**Re Development at the Old Garage Site, Dunsop Bridge**  
**planning approval ref: 3/2022/0082**

Please find enclosed on behalf of our client, The Duchy of Lancaster, a variation of condition planning application in respect to the original planning approval ref 3/2022/0082 for the redevelopment at the Old Garage Site, Dunsop Bridge.

SOUTH ELEVATION (A - A)

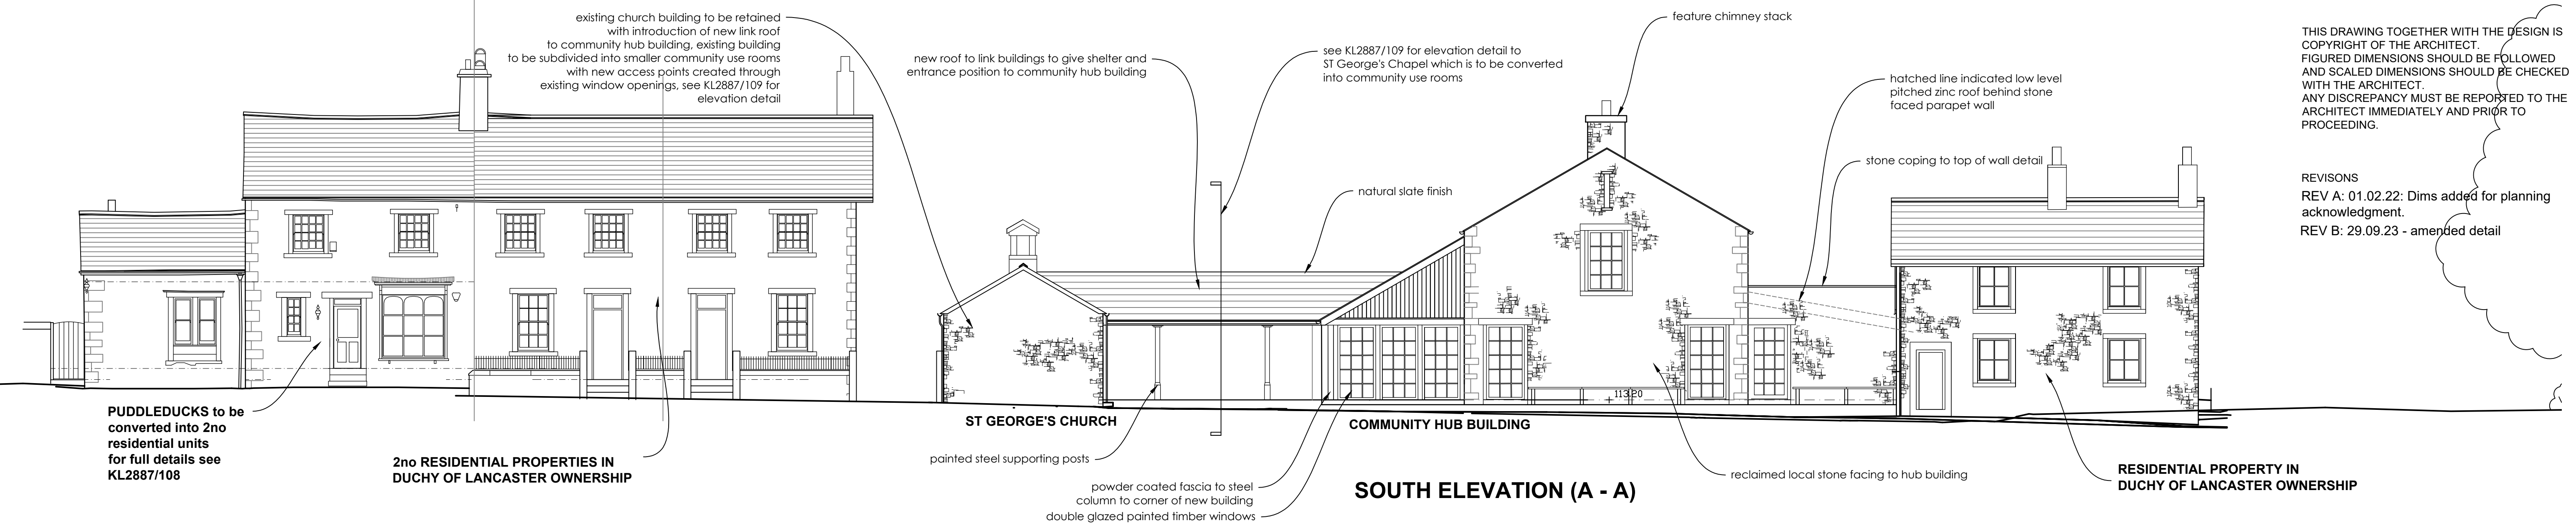
- The fenestration detail to the front (south) elevation has been amended. On reflection it was felt that the plate glass/ large pain format was too contemporary for the approach to Dunsop Bridge, so the detail has been reorganised into a more traditional format and scale.

- Feature bench seats have been added to the front (south) elevation to allow for informal seating to the south orientation.

Client	The Duchy of Lancaster		
Contract	OLD GARAGE SITE Dunsop Bridge		
Drawing title	PROPOSED ELEVATIONS		
Scale	Job No.	Dwg No.	
1:100	KL2887	107	B

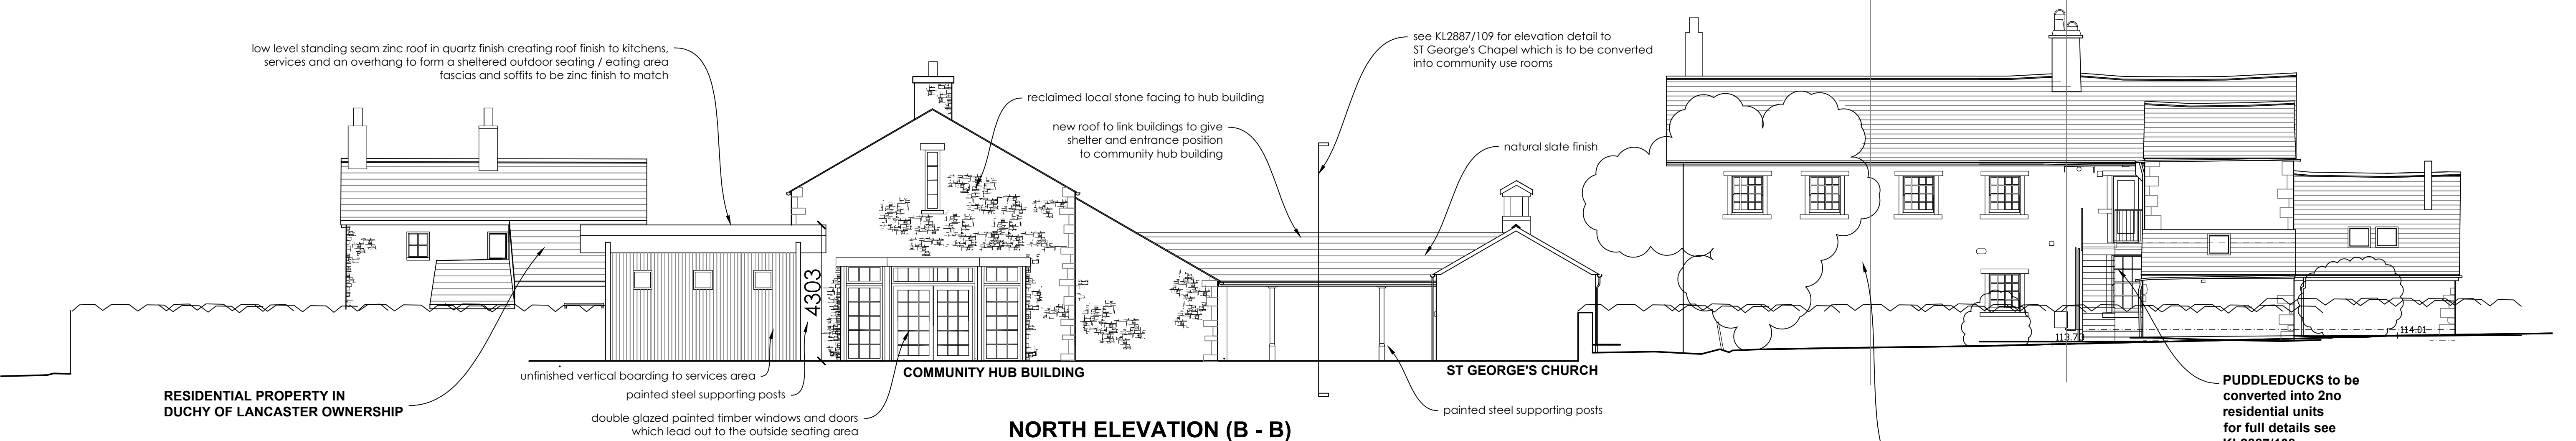
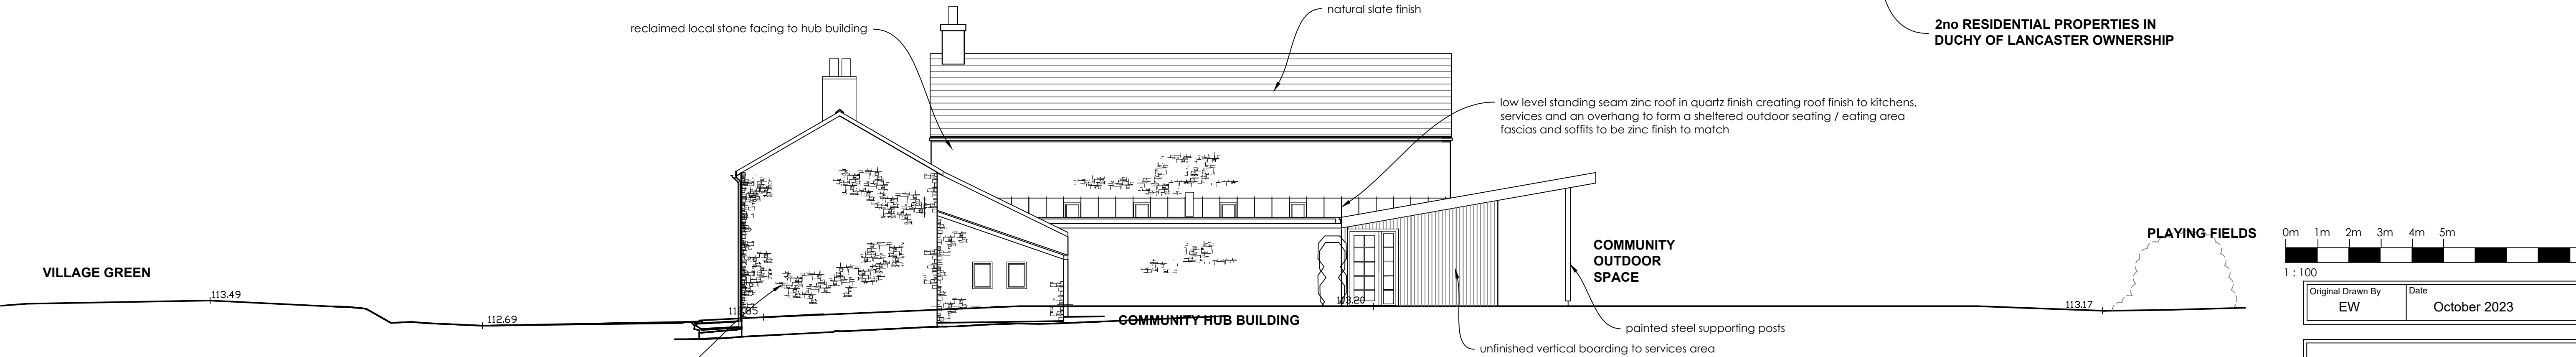
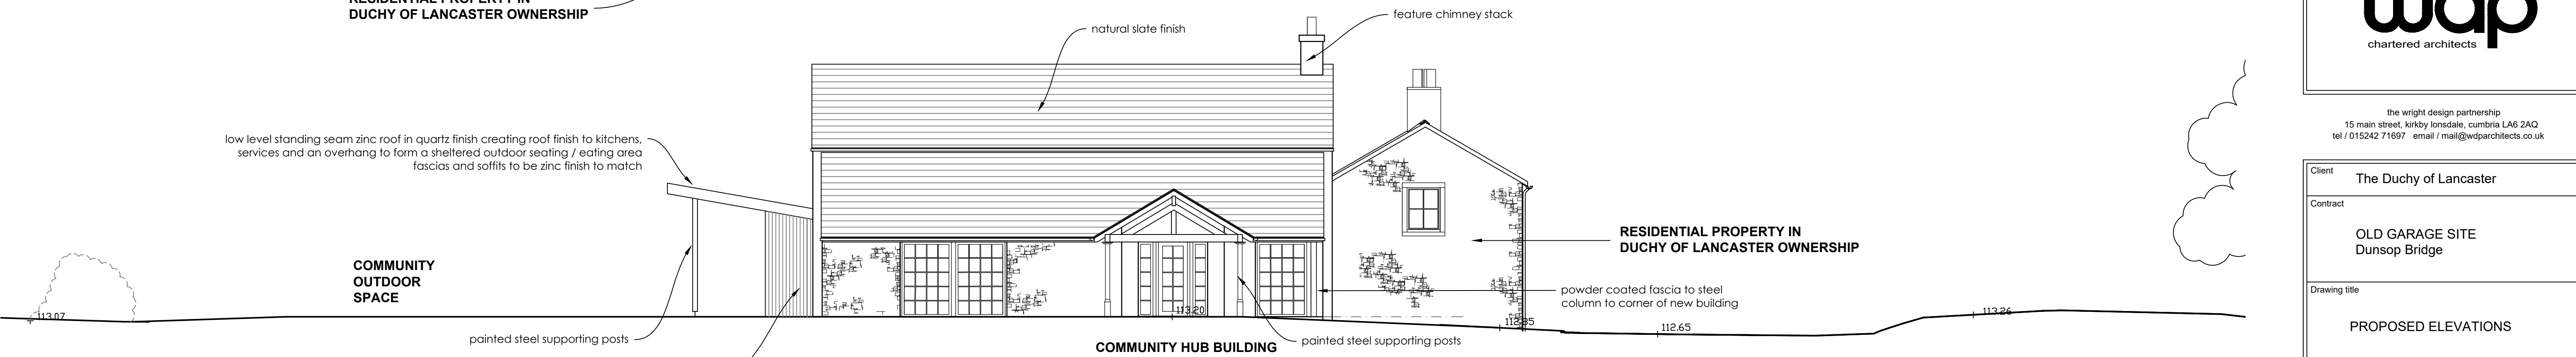
- The main roof to the hub building has introduced a step in the slate line to emphasis the double storey element, the original main ridge height is as approved with the side roof lowered.

- The subdivision of the windows throughout the hub building revised. Again, the more traditional approach to the window detail and subdivision was felt to be more appropriate in this location.

- The height of the link roof has lowered in response to the lowering of the hub side roof, this now ensures this new link roof is subservient to the original chapel roof and ridge line.

- All windows and glazed doors are now proposed as double-glazed painted timber frames. Painted timber frames (with all timber sourced from sustainable suppliers) is felt to be the more sensitive approach and more sustainable.

- The plant room / store has been amended to a vertically boarded timber finish to all elevations, retaining the slate roof over with a second set of access doors incorporated to allow the building to be spilt with separate access for the plan equipment and for site storage elements.
